Recommendation Report for Planning Permission for Works or Extension to a Dwelling

REF NO: BN/33/22/HH

LOCATION: 9 Elm Grove South
Barnham
PO22 0EJ

PROPOSAL: Single storey side and rear extension

sheet 1 of 3

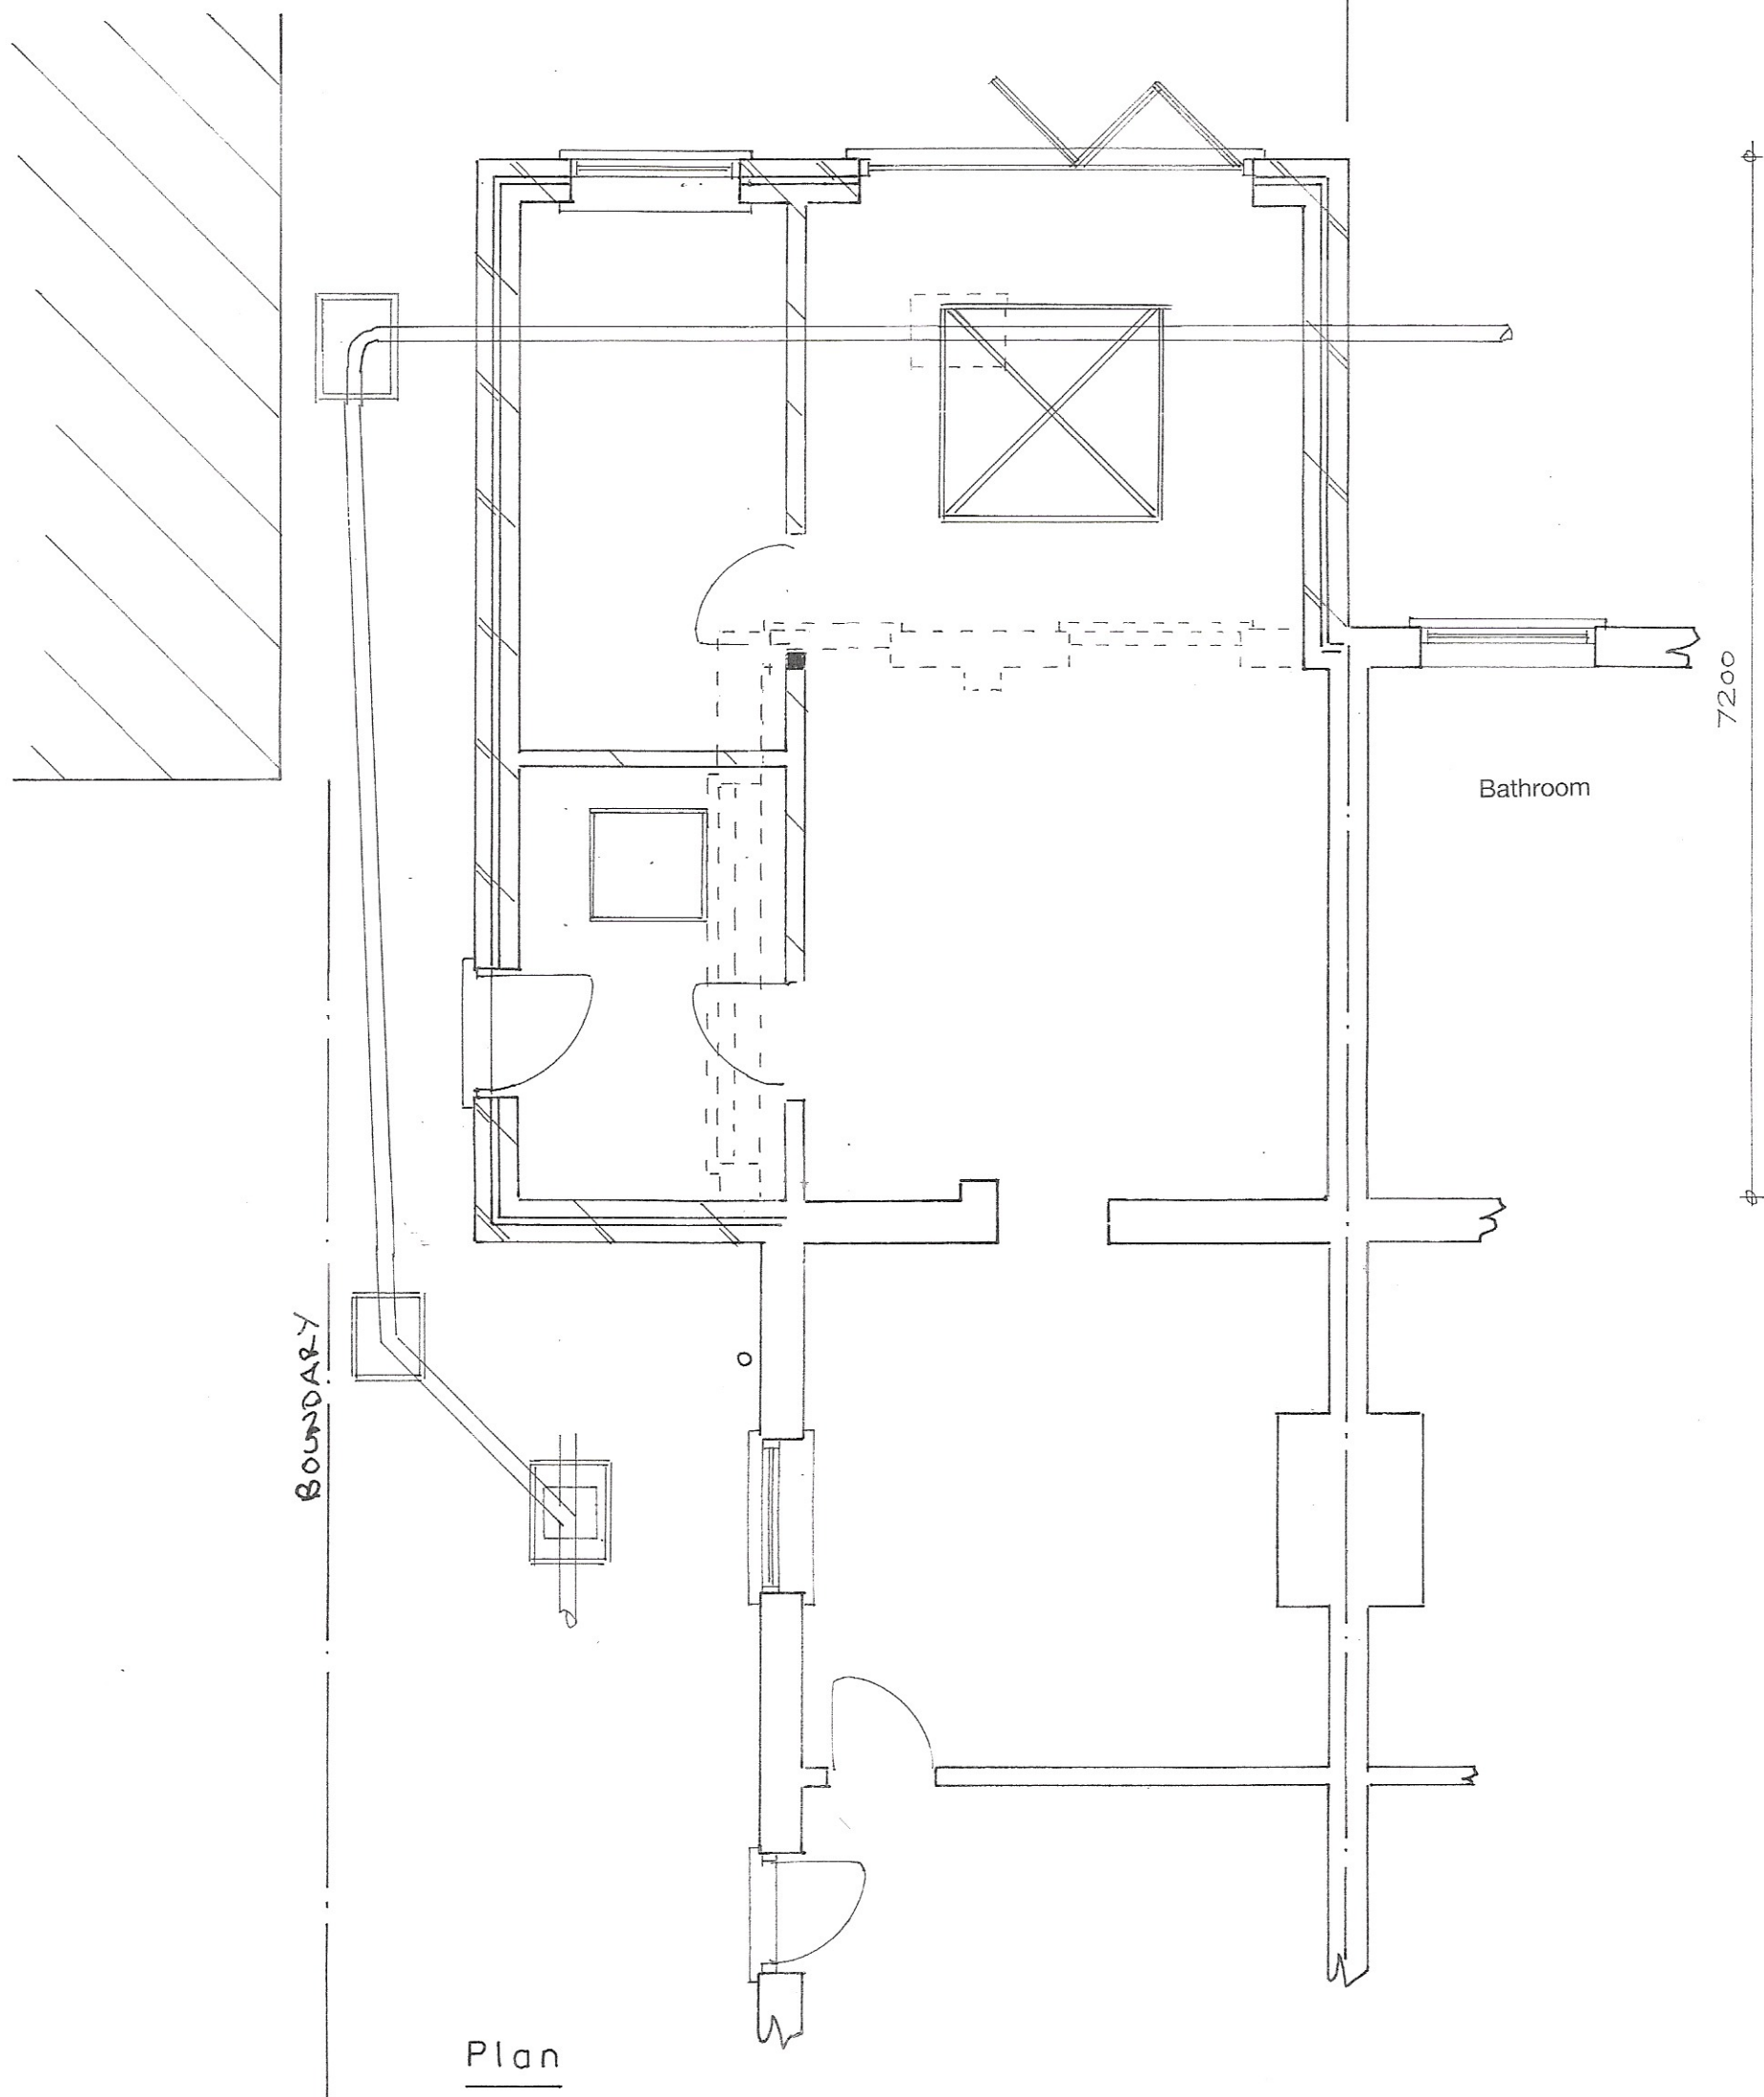
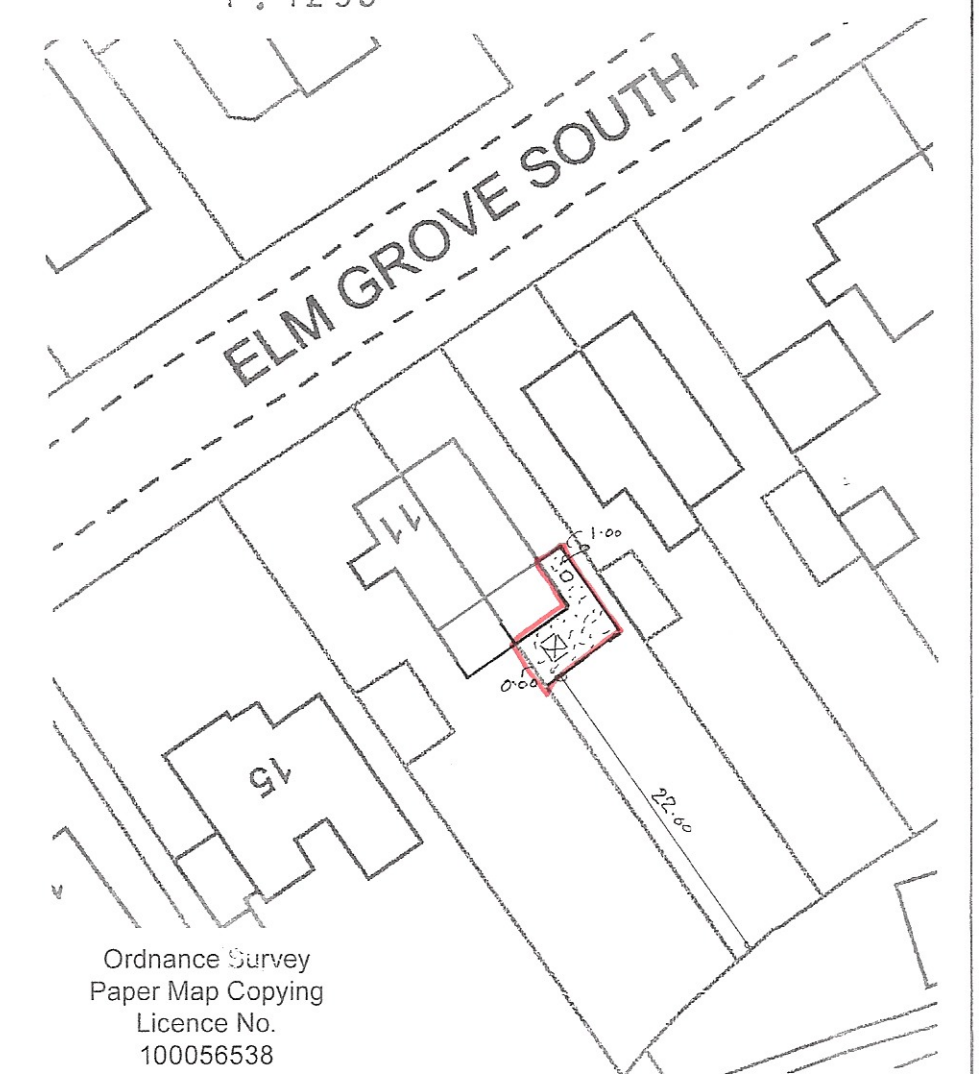
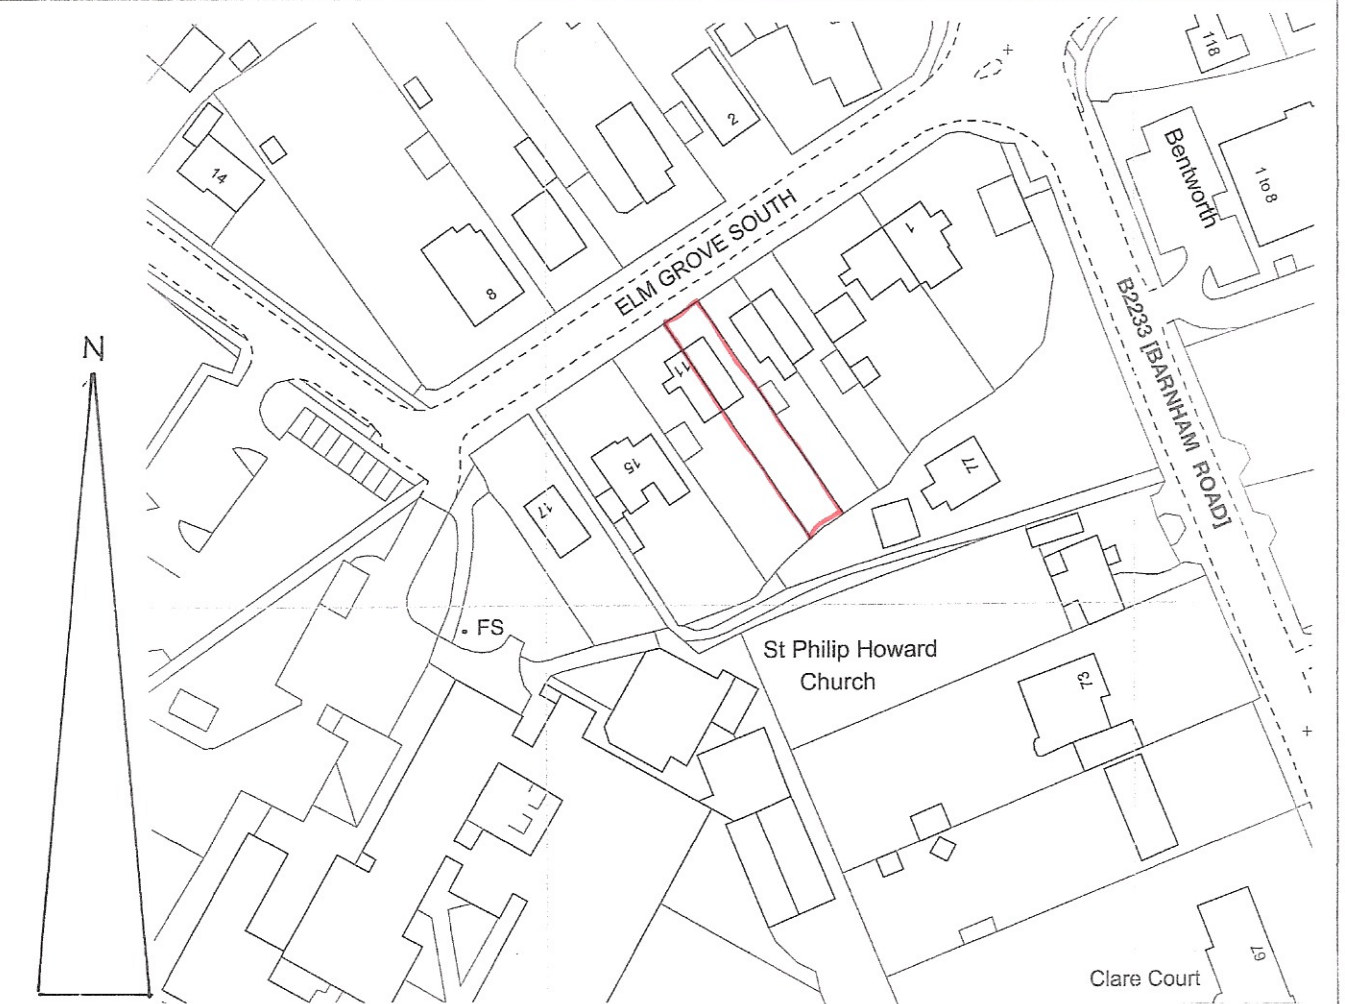
The extension is a modest size and will wrap around the rear and side elevation of the property. The side component will protrude 1.98m deep to the east, the rear 3.22m to the south. The proposal will have a total width of 4.05m and 7.5m. It will have a flat roof matching that of part of the existing property, helping to integrate the proposal sympathetically with the existing. This flat roof will differ to that of the main roof, but is not out of character with the property, and will have minimal impact on its visual appearance.

The proposal is single storey and has a flat roof at a height of approximately 2.86m. This roof will incorporate a roof lantern and roof light, both of which will protrude slightly above the roof line but will have no impact on residential amenity. 1m will be retained to the east boundary, 22m to the south (rear), and 0m to the west.

Given the distance from No.7 to the east, the proposal poses no risk of adverse overbearing or overshadowing of this neighbour and is acceptable. Being on the boundary with No.11, the extension

poses some risk of overshadowing and overbearing. The Arun Design Guide recommends using the 60-degree and 45-degree tests to ascertain if the proposal affects neighbours' access to light. The proposal does conflict both these when taken from the nearest window but considering this is the window for the neighbour's bathroom, the impact is not considered to be unacceptable as it is not living accommodation, and will not be unduly harmful to their amenity. The extension is in accord with D DM4 and will not result in adverse harm to residential amenity.

sheet 2 of 3

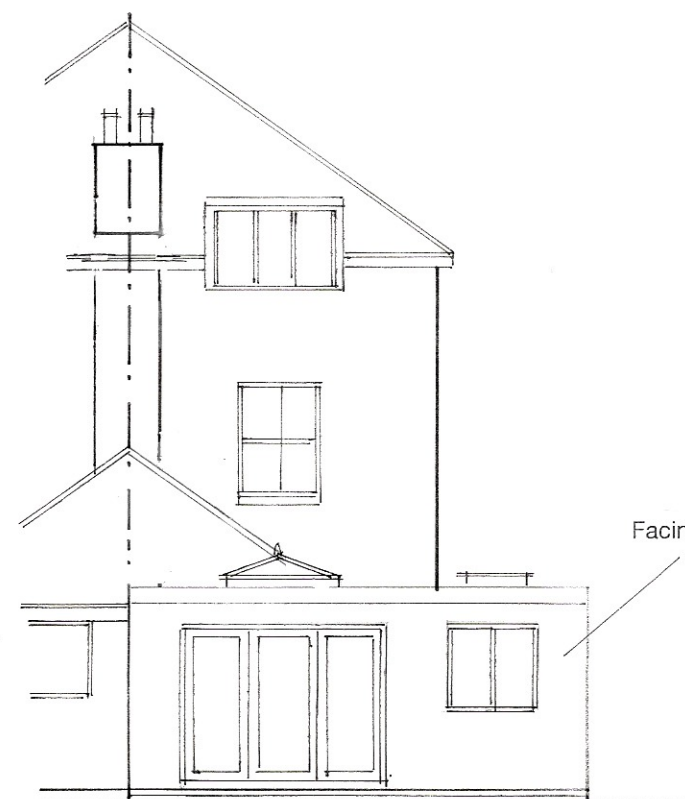
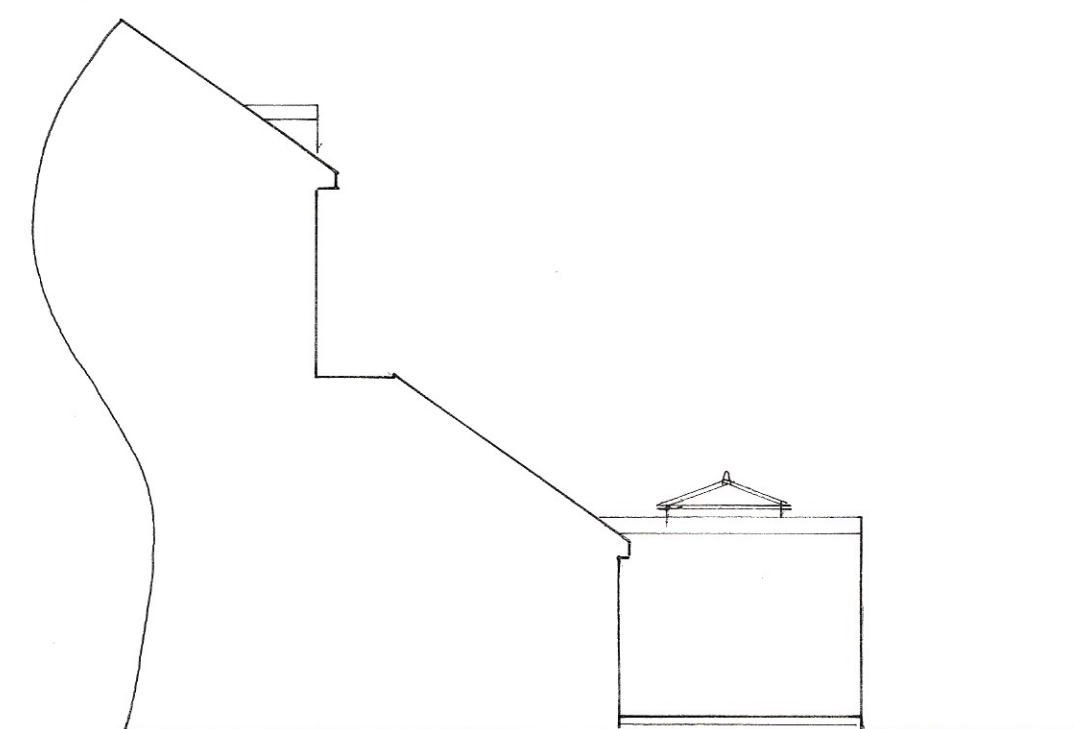
As part of the proposal is to the side, this component will be visible from the street scene. However, this visibility will be limited due to its proximity from the front boundary, and will be blocked in part by neighbouring properties to the side. As such it will only be visible when stood to the front of the property, and therefore will have little impact on the composition and appearance of the street. The proposal is in keeping with the character of the property and the locality, and is acceptable, posing no risk of adverse harm to visual amenity.

In addition to the rooflights, the proposal will feature bi fold doors and a window to the south elevation, and a door to the east. These features do not unduly overlook any neighbouring properties and pose no risk of harm to residential privacy or amenity.
